# MDT-SF21026-R4-GEC.pdf Markup Summary

**Subject:** Stormwater Comments Color  
**Page Index:** 1  
**Date:** 2/2/2022 2:17:21 PM  
**Author:** dotprete  
**Color:** ■  
**Layer:**  
**Space:**  
**Page Label:** 1

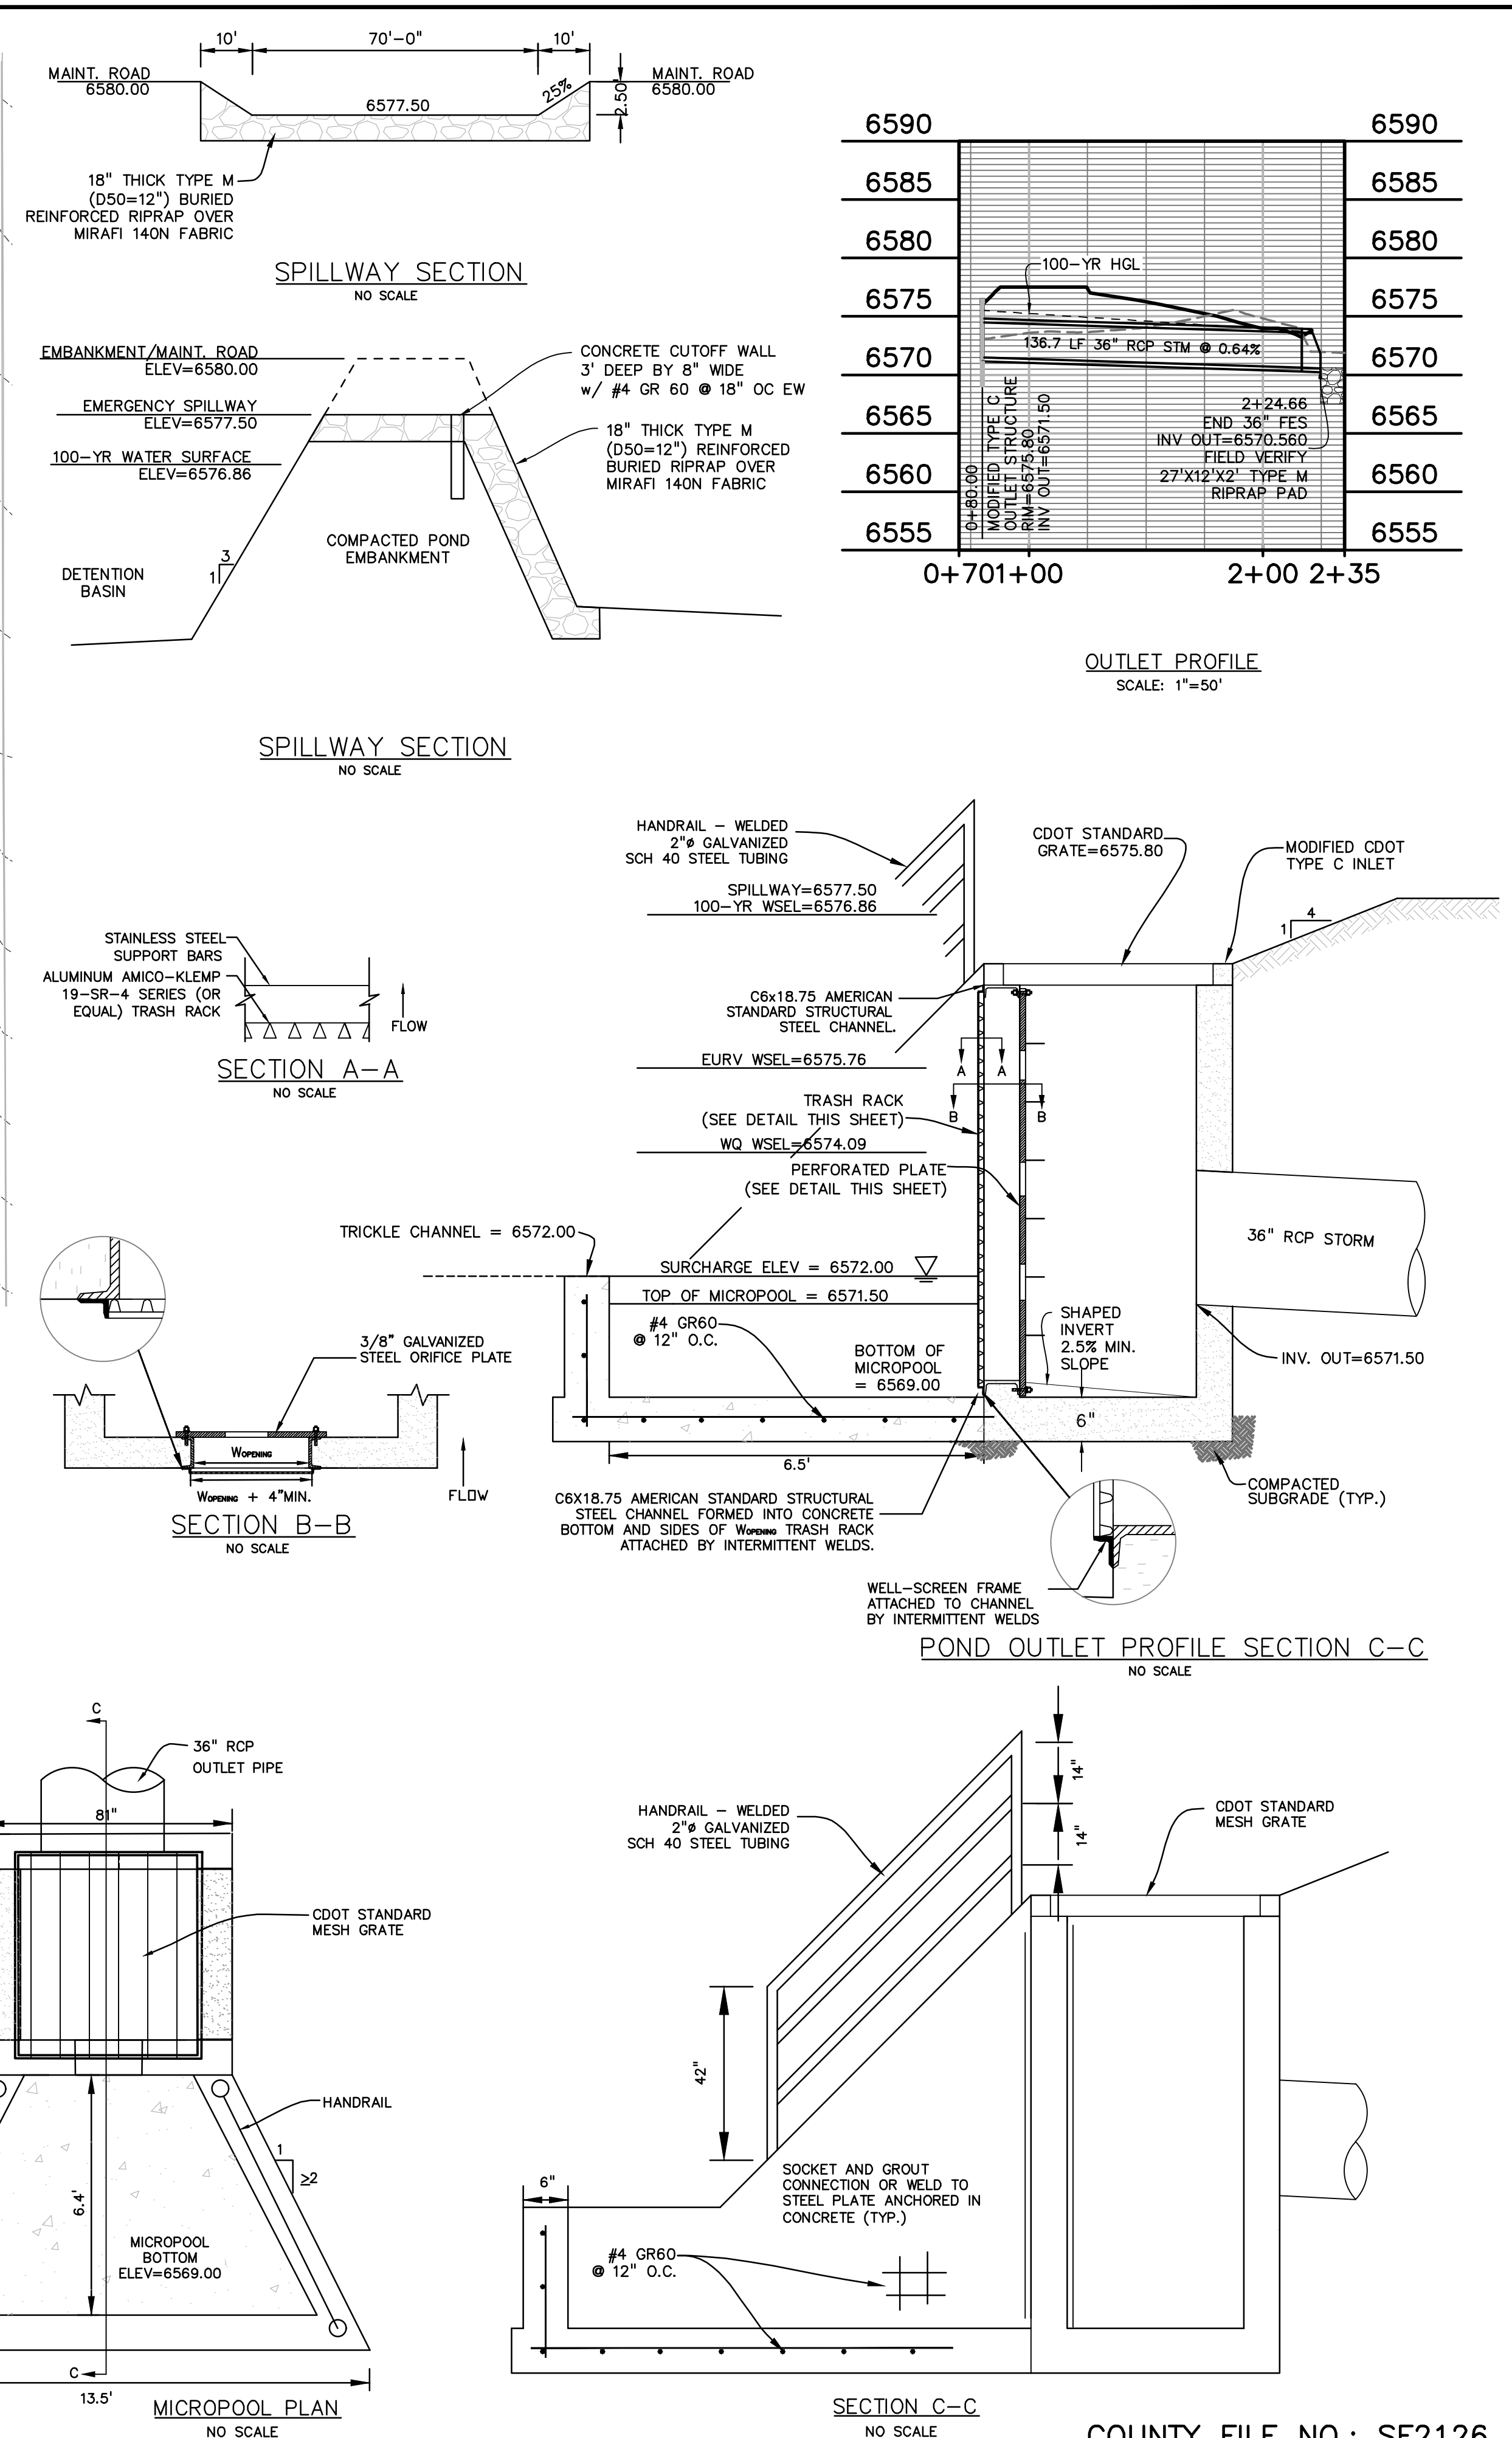
riprap pad dimintions do not meet requirements in drainage report
